**HIGHWAYS ENGLAND CUSTOMER CONTACT CENTRE  
CALL REFERENCE: 18891288**

South Somerset Bridleways Association

**Re: representation from the South Somerset Bridleways Association to the consultation on the A303 Sparkford to Ilchester Dualling scheme.**

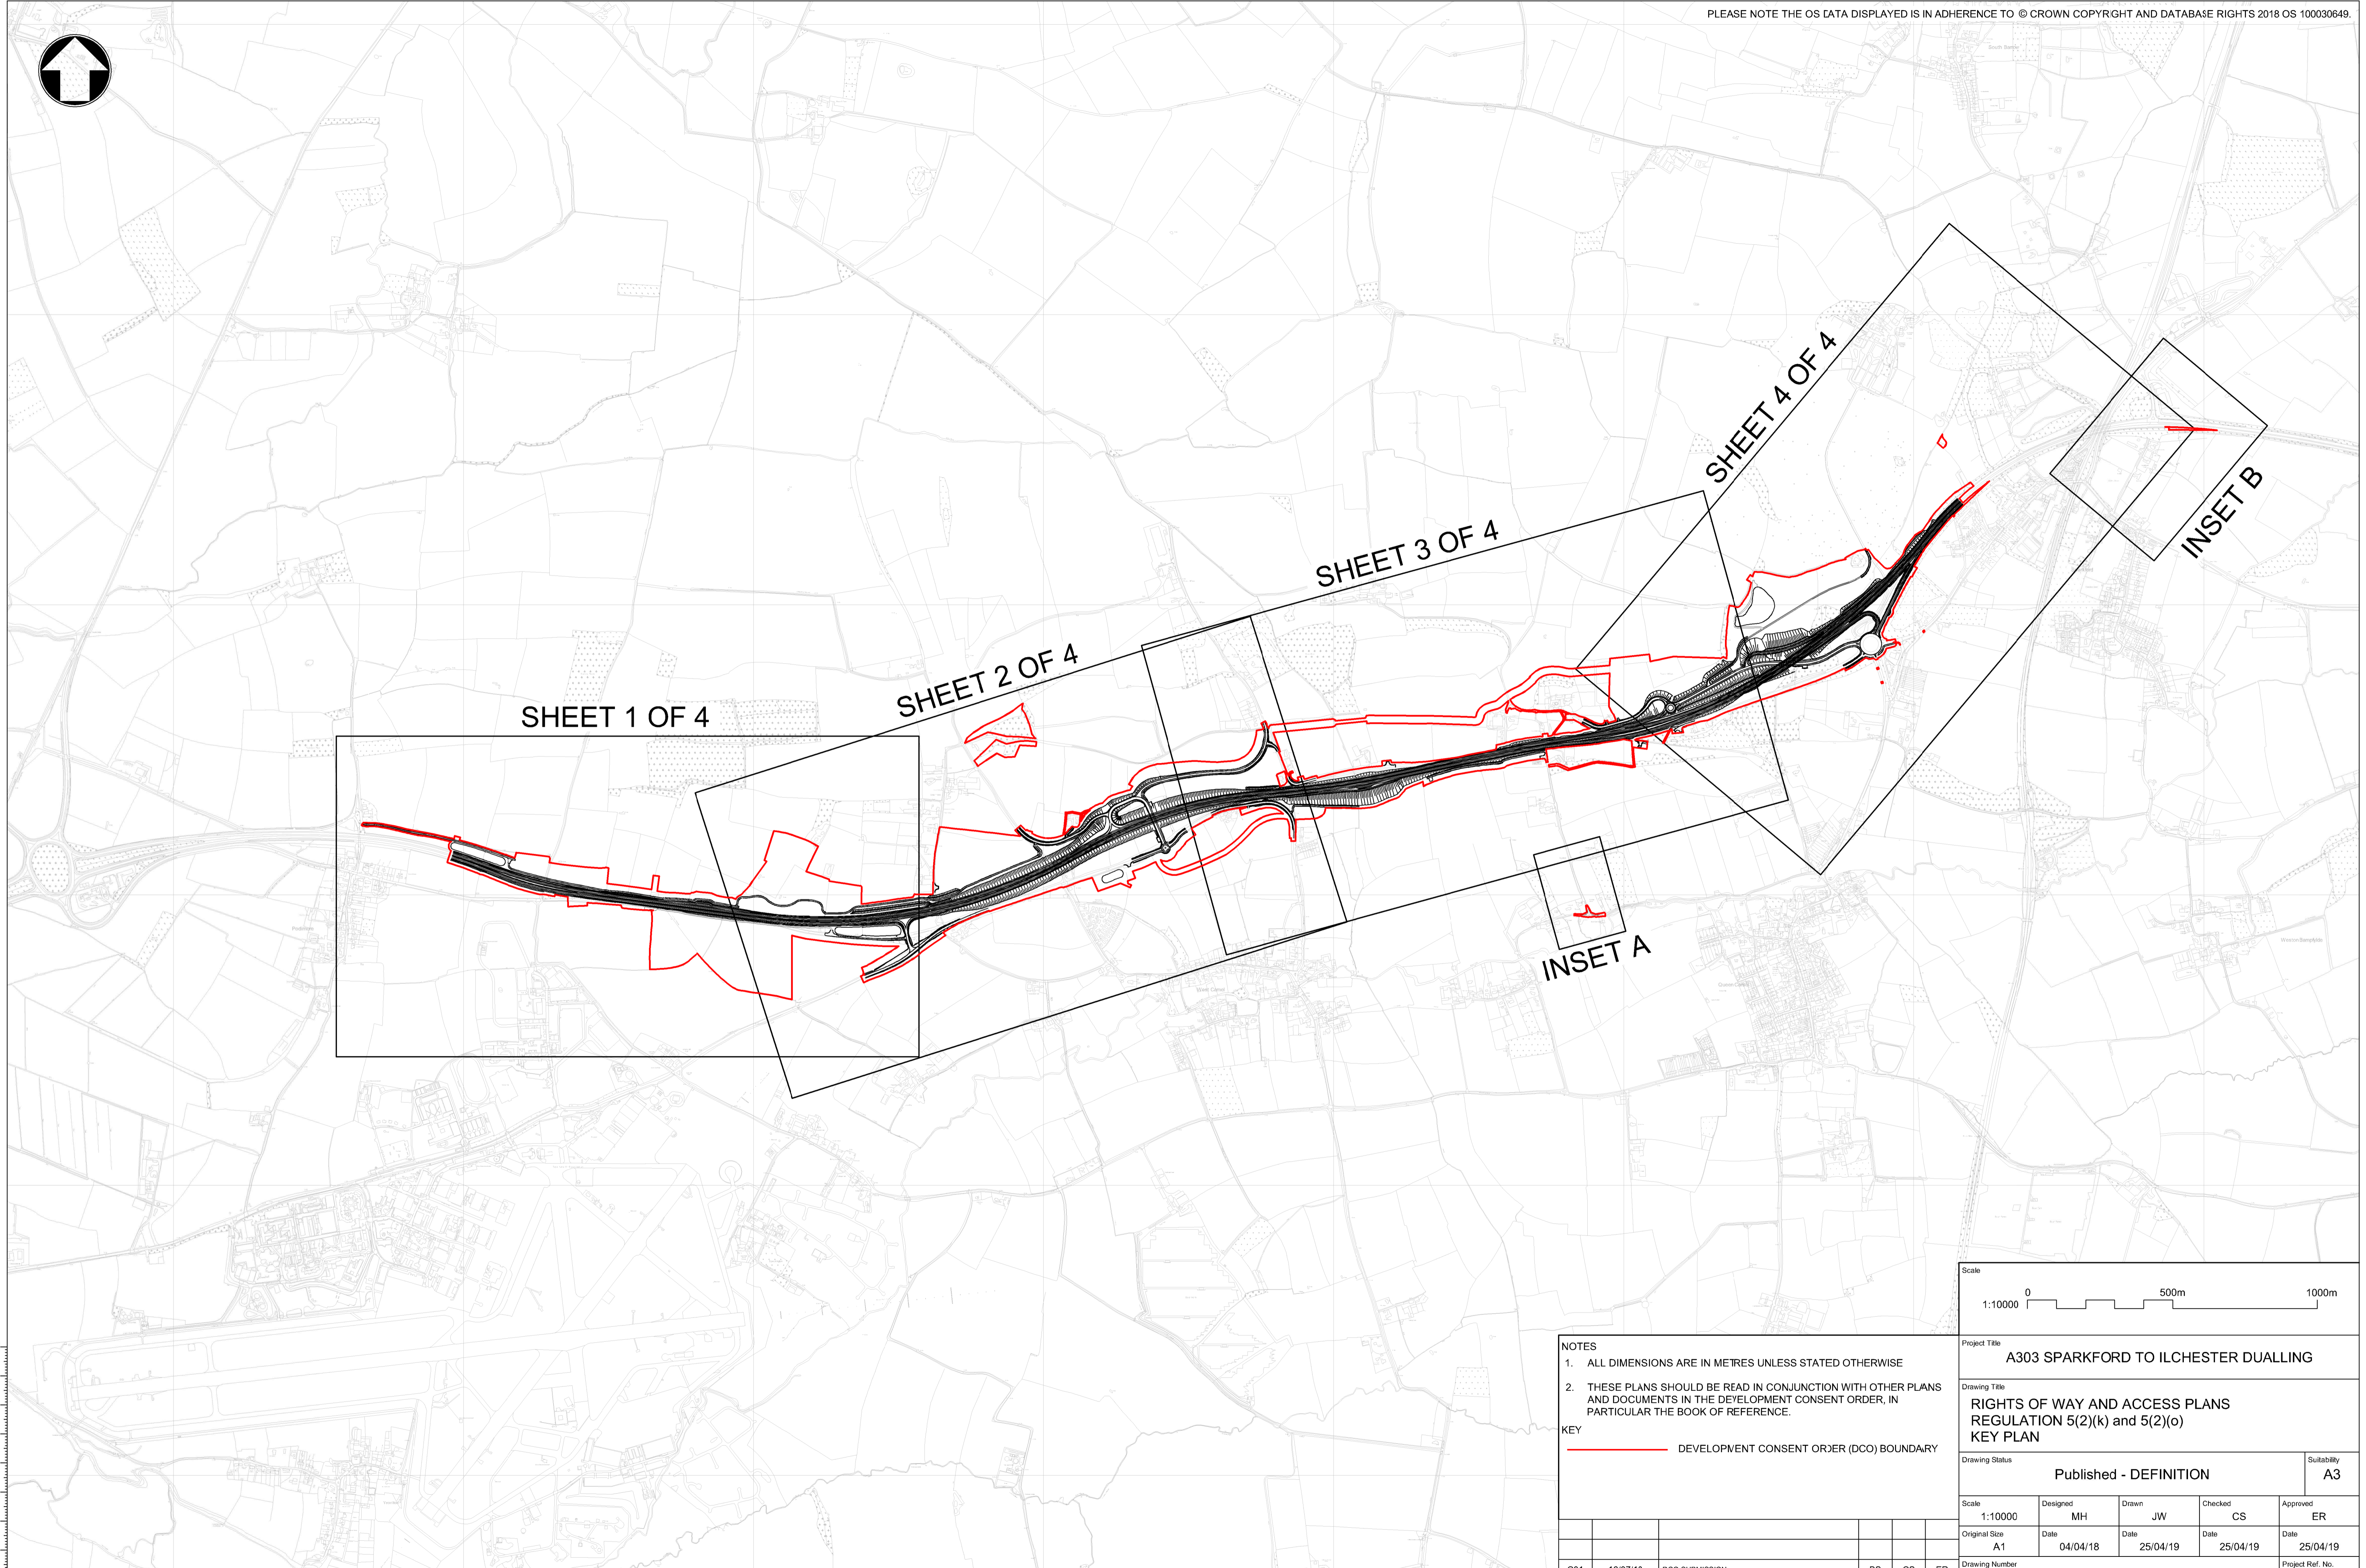
1. Southern end of Eastmead Lane (AA on sheet 1 of 4). The provision for a new NMU route is a detour eastwards to the new crossing at Steart Hill and back along the surface roads into Podimore. This is over 5 kilometres, making a round trip of over 10 kilometres, and is considered too long. Although outside the area covered by the DCO scheme, it would be helpful if provision could also be made to connect up the bridleway (Y30/29) into Podimore across the vehicular bridge. This bridleway (Y30/29) was dedicated in the 1996 side roads order by the Highways Agency, the predecessor body to Highways England.

INSET E: EXISTING ROADS AND PROW TO BE STOPPED UP

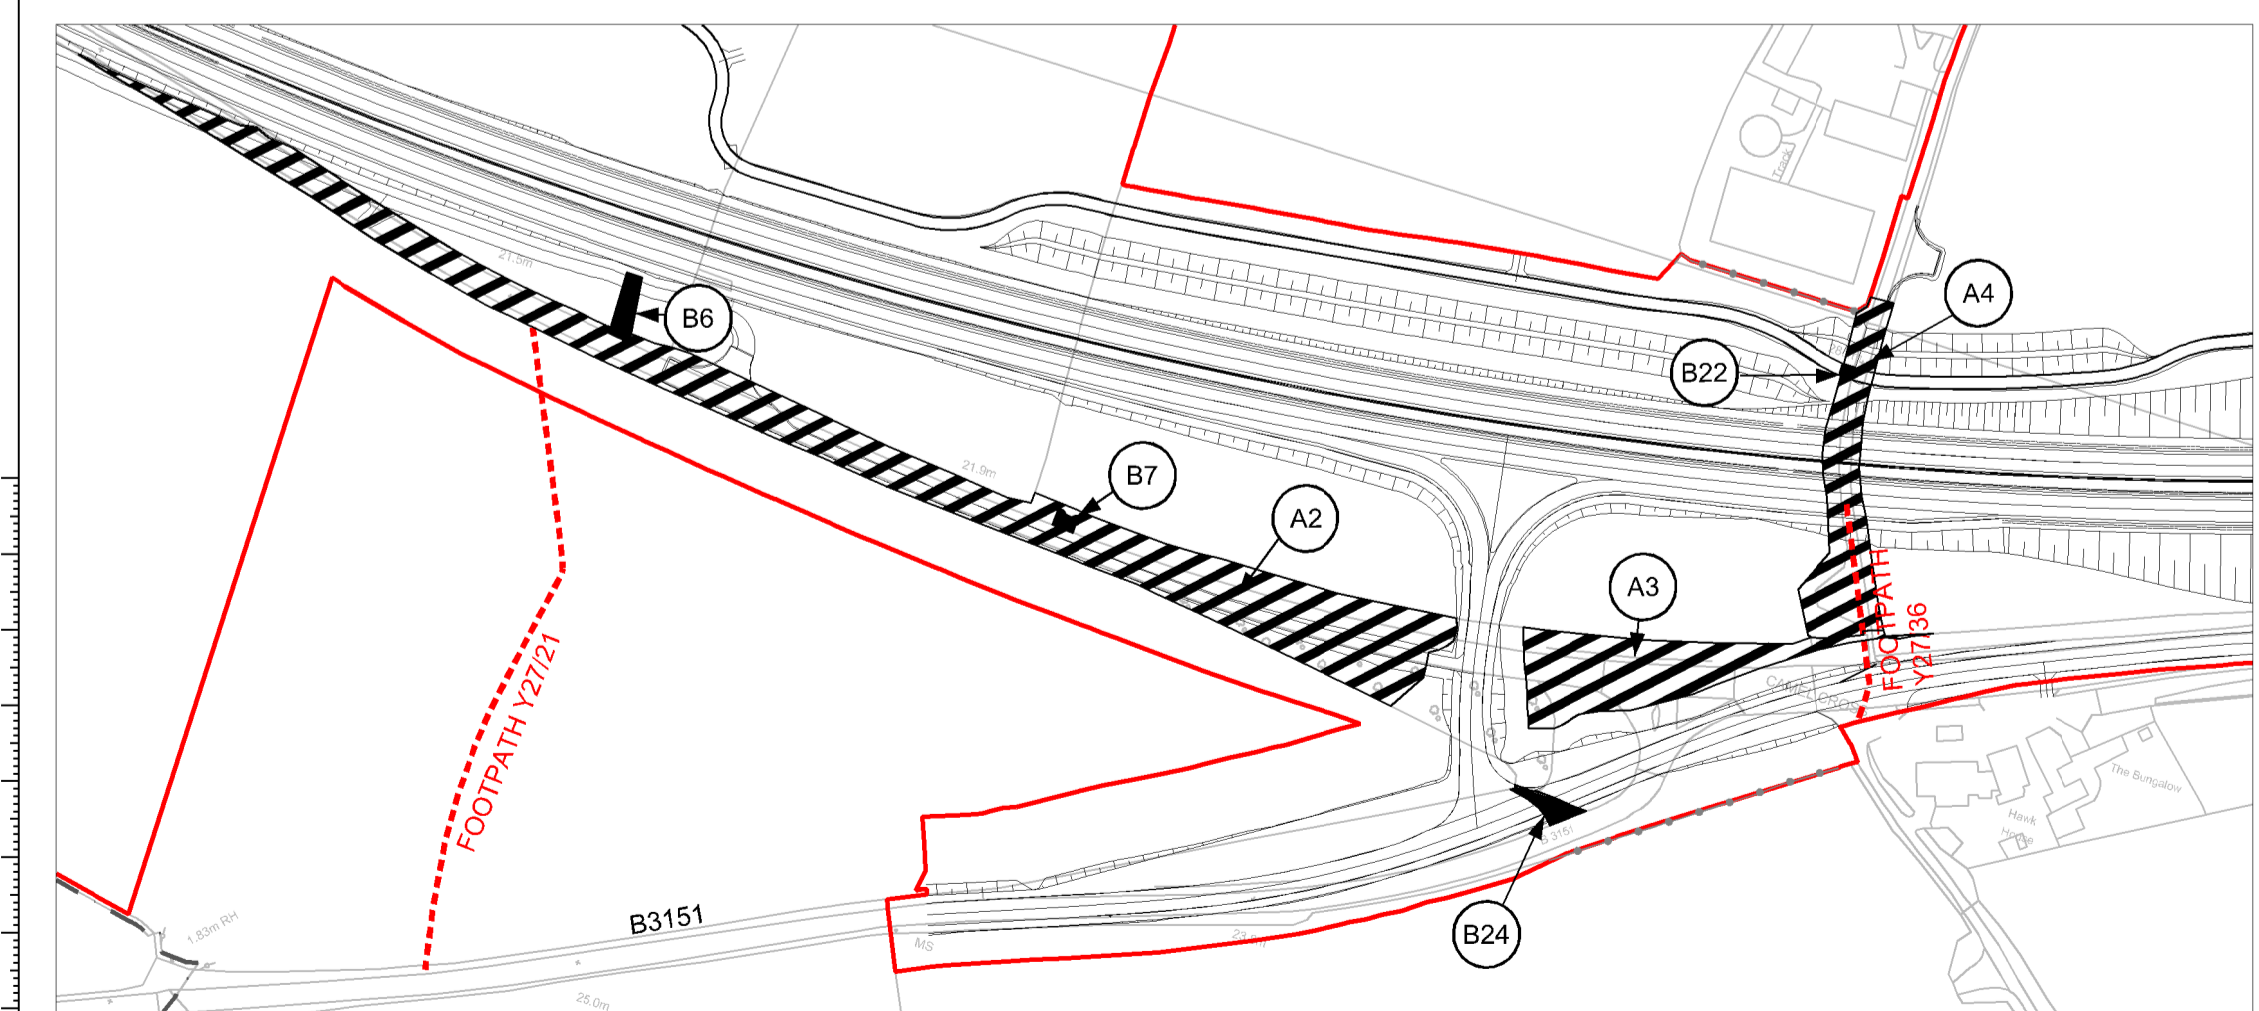
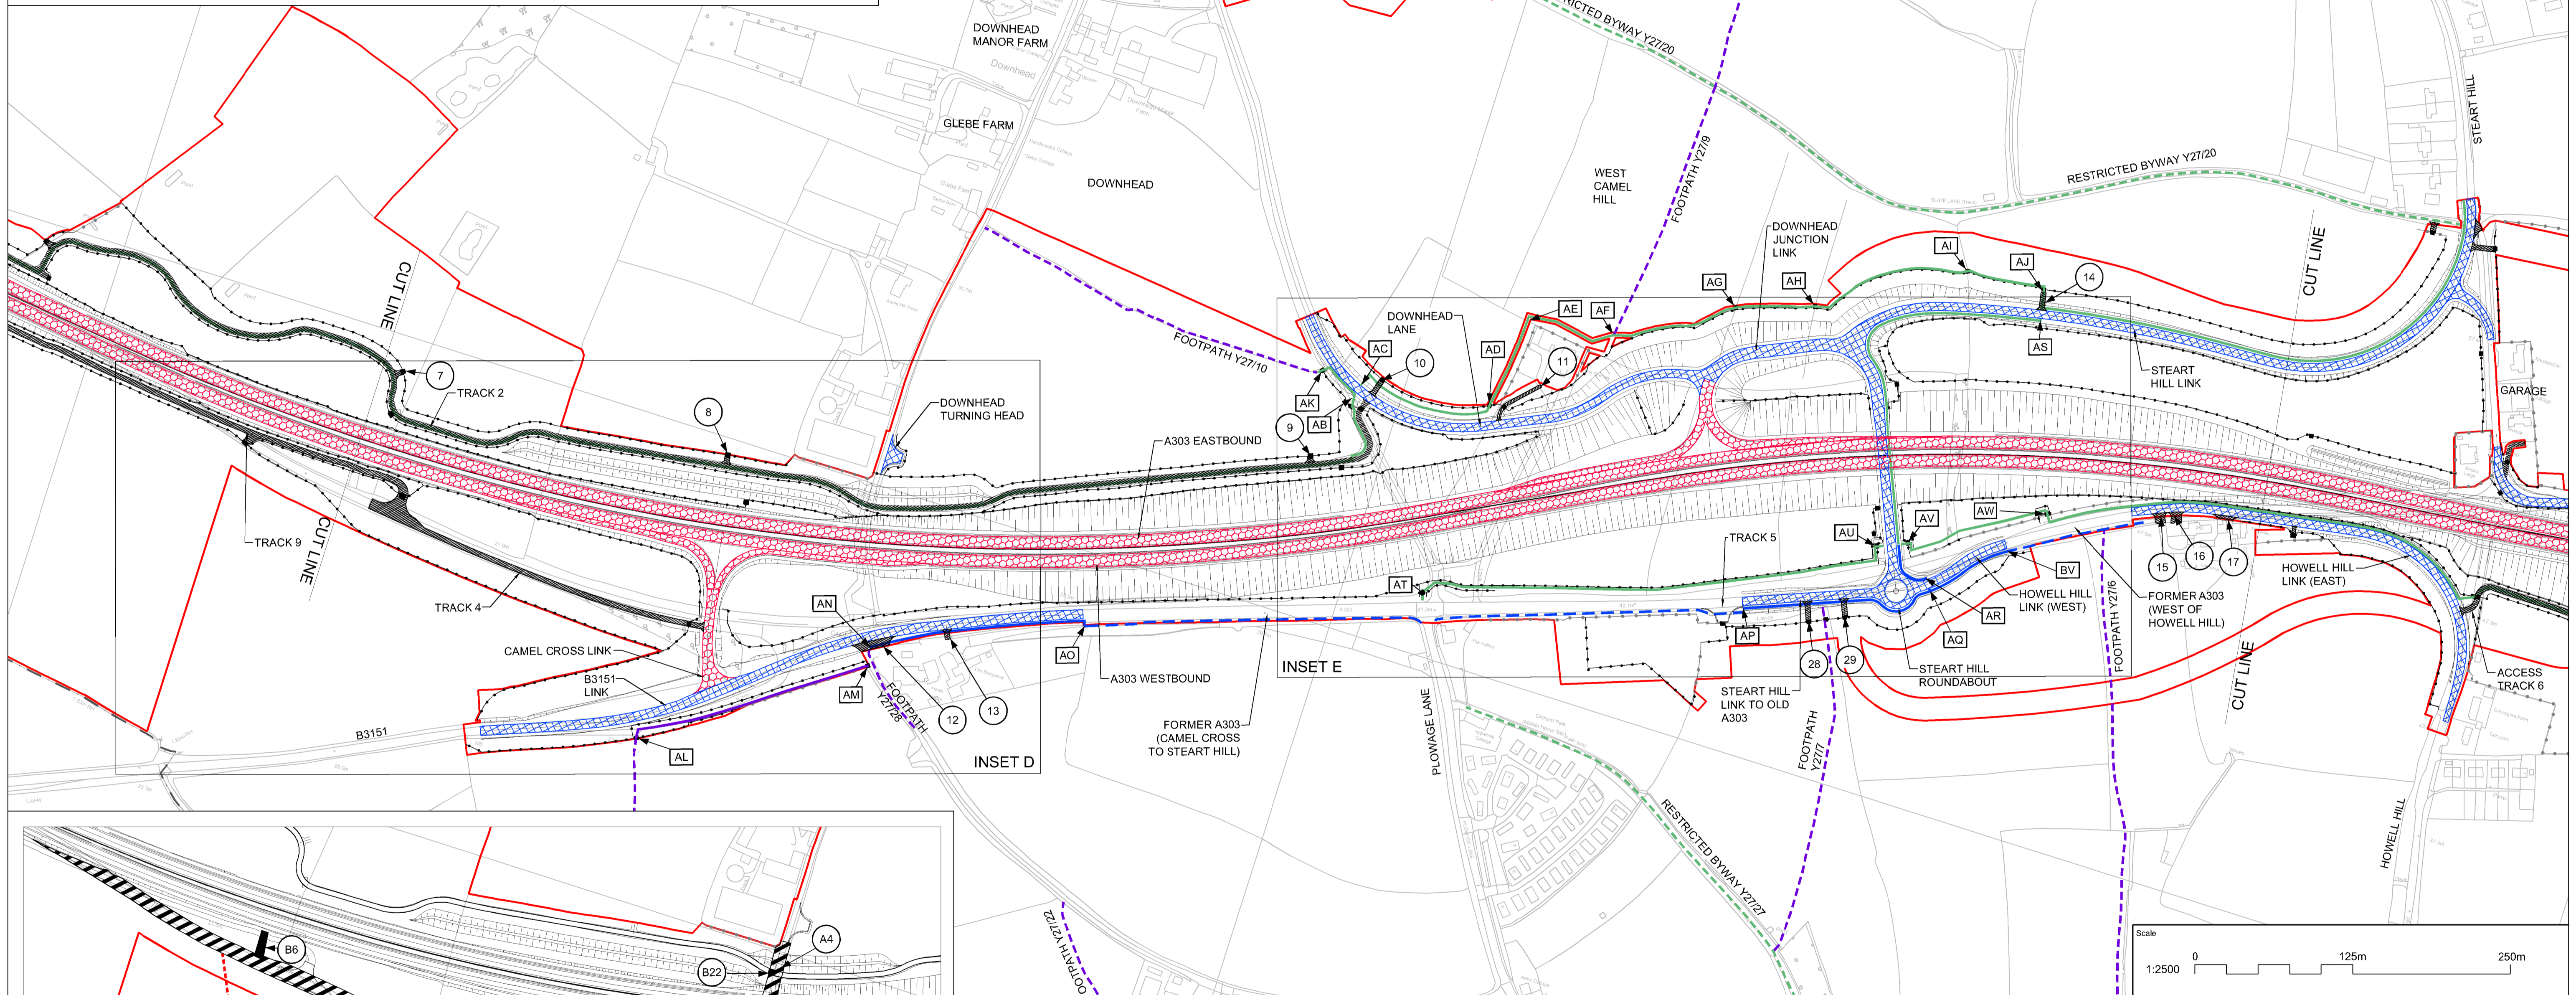
8. Northern end of Plowage Lane (AT on inset E, sheet 2 of 4). Please could consideration be given to installing a Pegasus crossing at this point. There is a restricted byway just to the south of this point, and also the horse riders and cyclists using the old A303 will wish to join the new bridge from the new Steart Hill roundabout. These NMU will need to cross this road at point AT. Please could consideration be given for a Pegasus crossing at this point.
